From: [REDACTED]
To: [West Burton Solar Project](#)
Cc: [REDACTED]
Subject: Action Point 3 from ISH4
Date: 28 February 2024 22:29:10

In response to action point 3 from ISH4, Nottinghamshire CC and Lincolnshire CC have agreed on the following comments regarding the West Burton WSI's in respect of archaeology as presented by the promoters:

Comments of Lincolnshire CC and Nottinghamshire CC to the West Burton WSI's regarding archaeology

Figure 4. Archaeological mitigation areas within West Burton 3

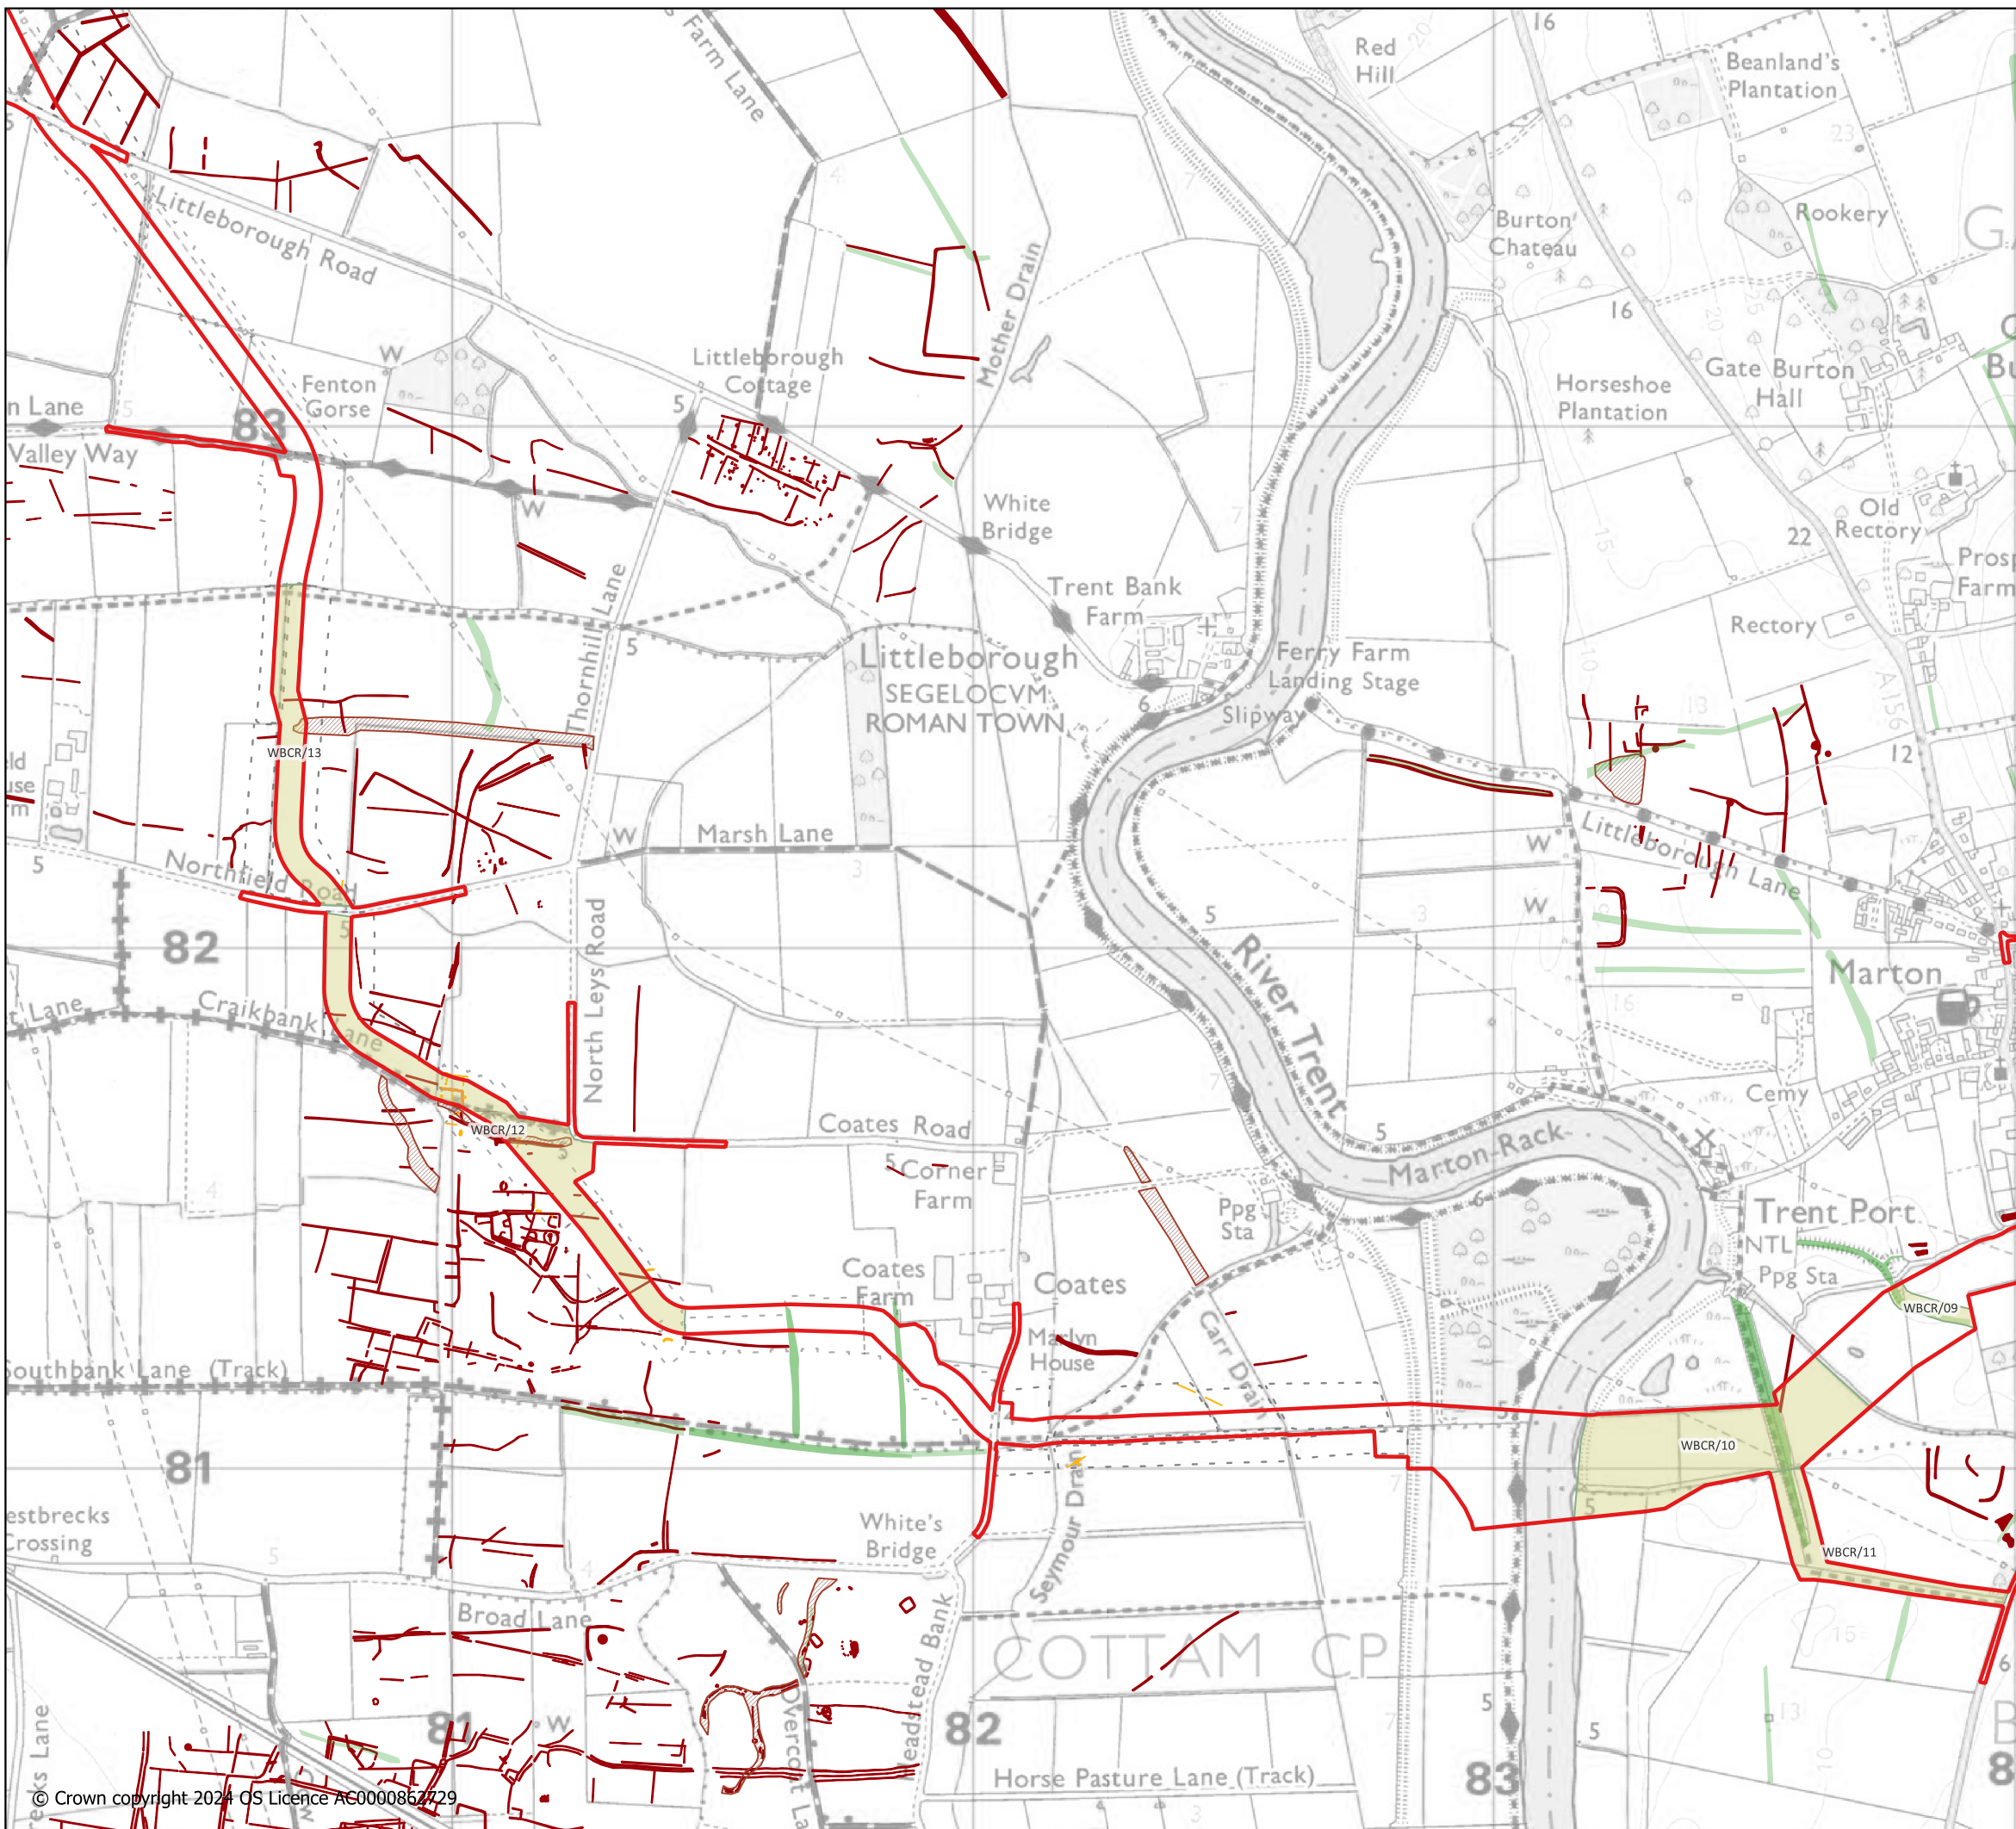
Regarding the figures, we have grave doubts regarding interpretation of the air photo and LIDAR features, for example Figure 4 which identifies banks as Post Medieval. Without intrusive investigation it is impossible to know the dates of these features. Some of these features do not align with Post Medieval field boundaries and some look like they may be part of Medieval settlement.
